New Wee Waa High School (SSD – 21854025) Response to Submissions

RE: New Wee Waa High School (SSD-21854025) – Public Authority Consultation (PAE-40130687)
Advice on Response to Submissions

Response to Submissions SSD21854025: Lot 124 & 125 DP 757125, Lot 2 DP 550633 and Lot 1 DP 577294, Mitchell Street (HW29), Wee Waa, Wee Waa High School

Figure 6.25
(Sheet 1 of 2)

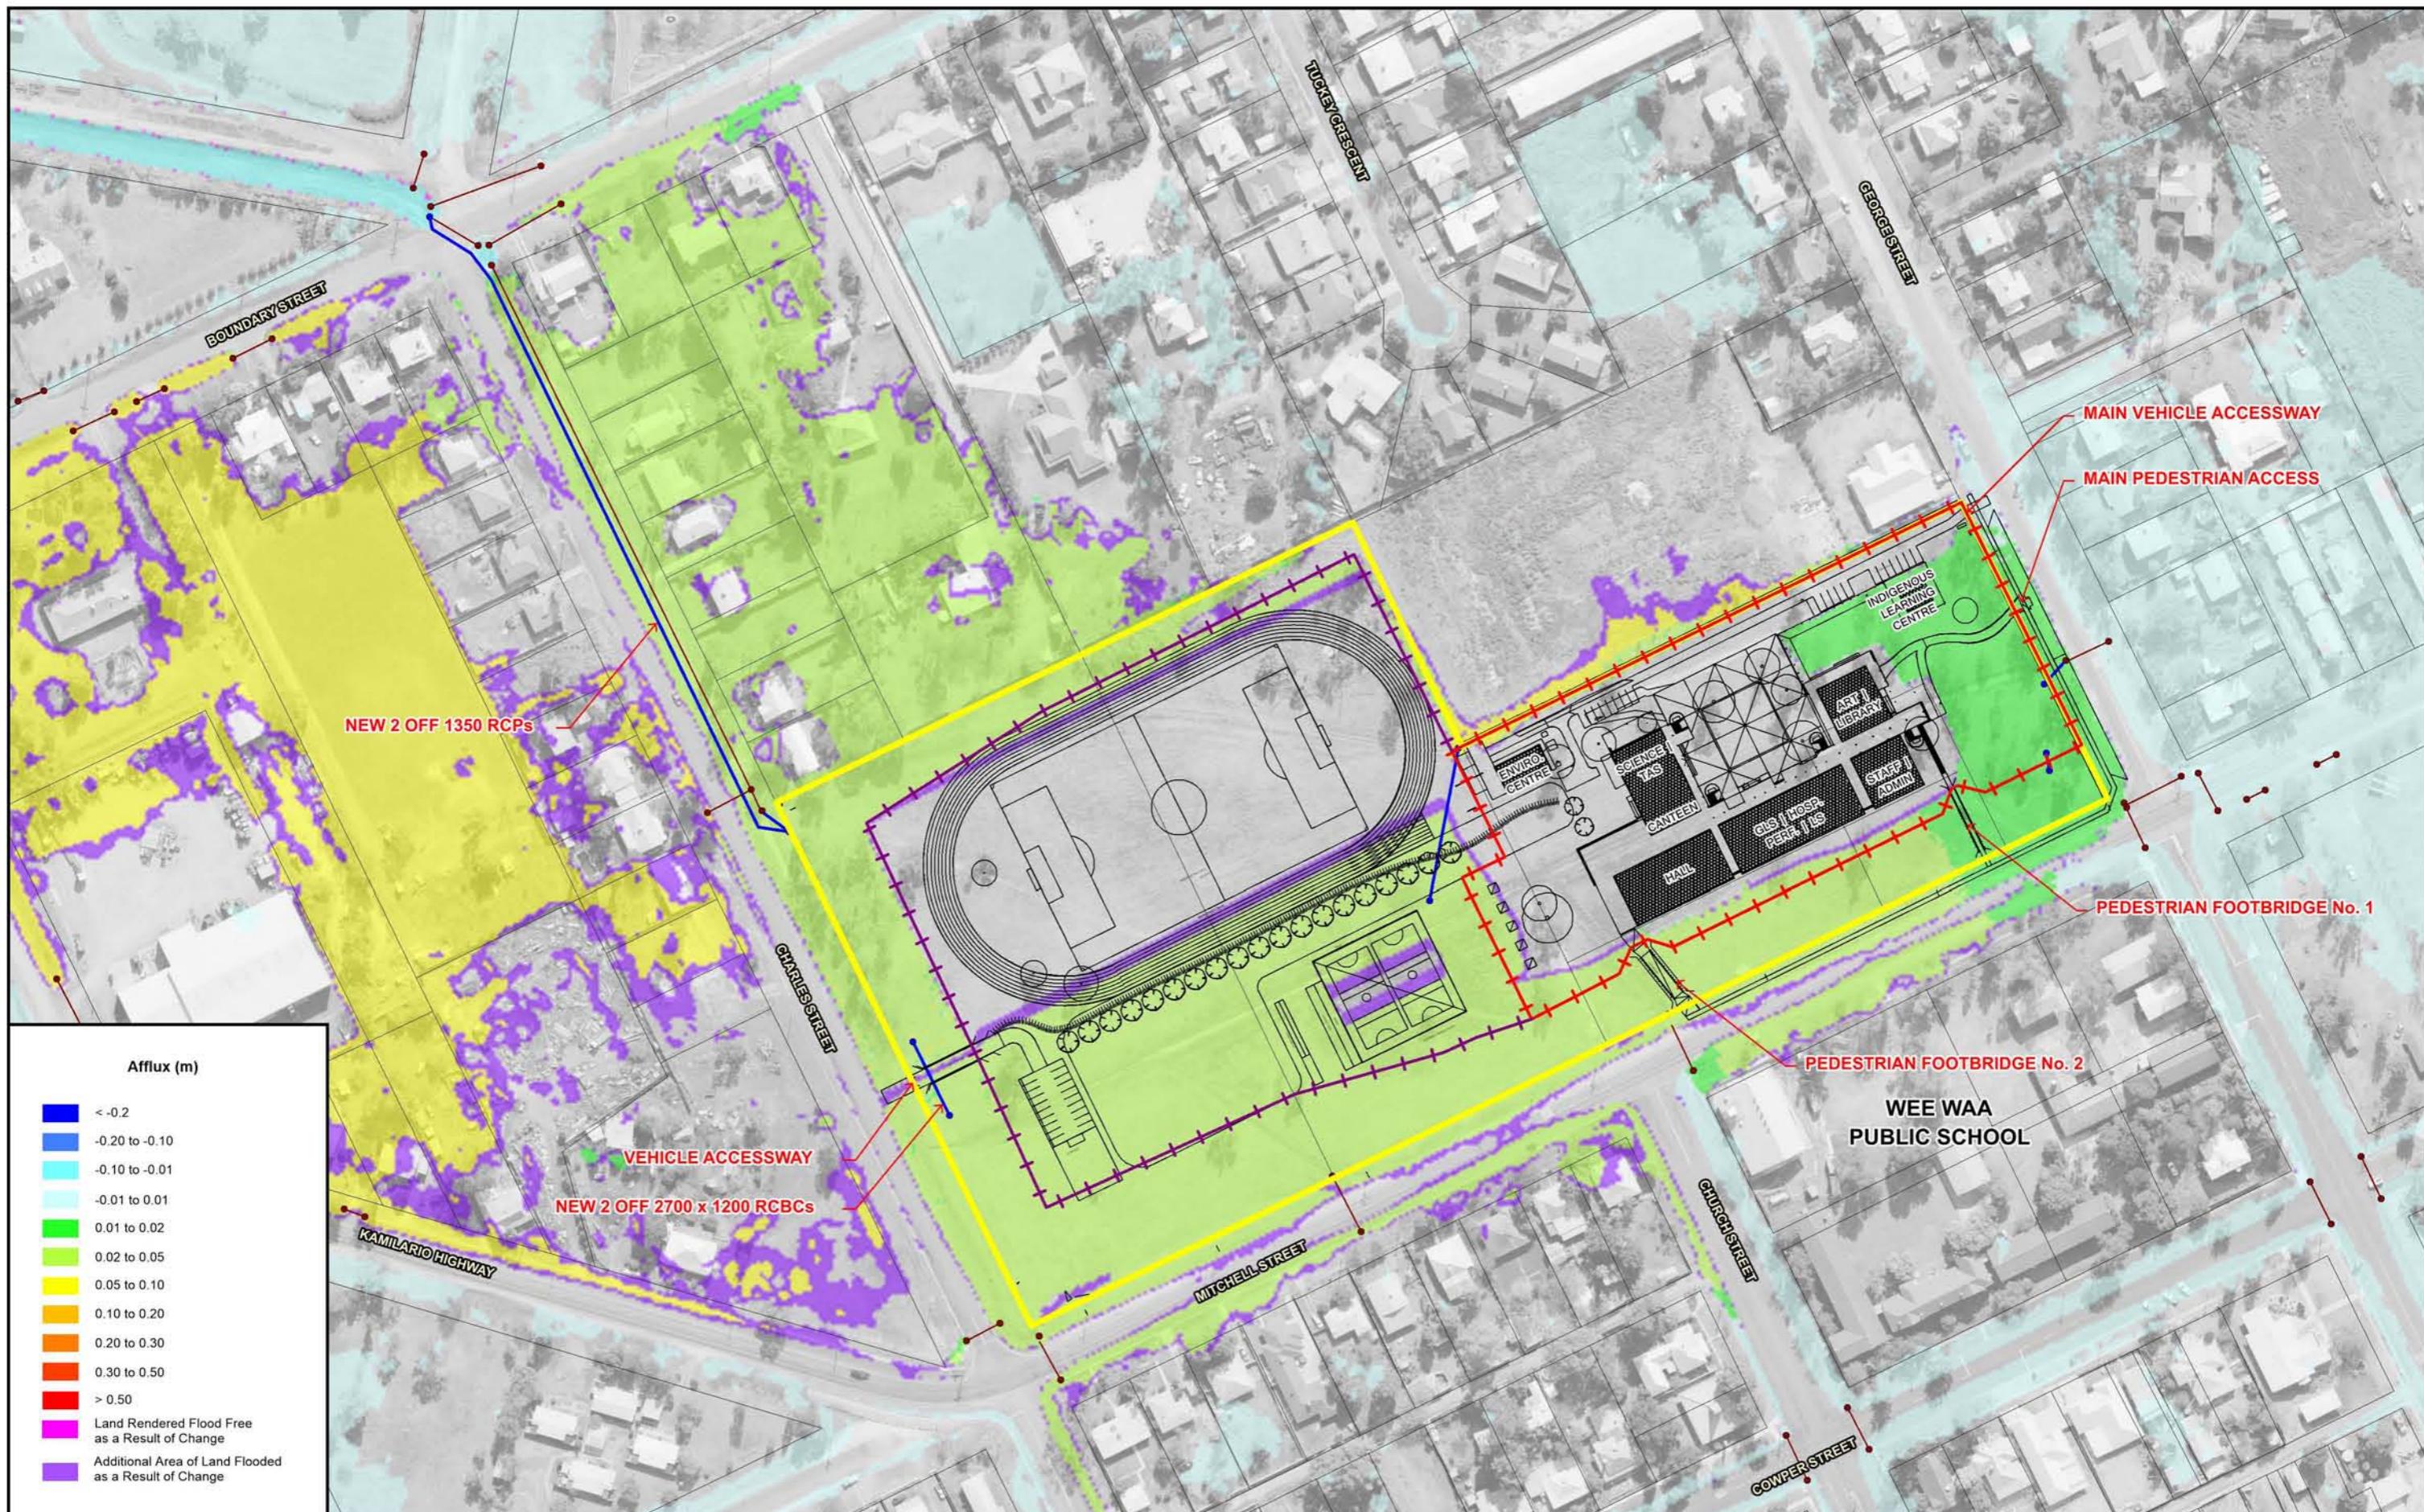
Further, a blockage assessment of the grated inlet and chain wire debris control device should be undertaken in accordance with Australian Rainfall and Runoff. The construction of a chain wire fence across a waterway is highly unusual and would be prone to blockage from small floating debris and urban rubbish. The failure of the fence could increase the chance of blocking the grated inlet, which may then inundate

properties along Charles Street. It is recommended that a blockage assessment of the Charles Street culverts, and inlet structure be undertaken.
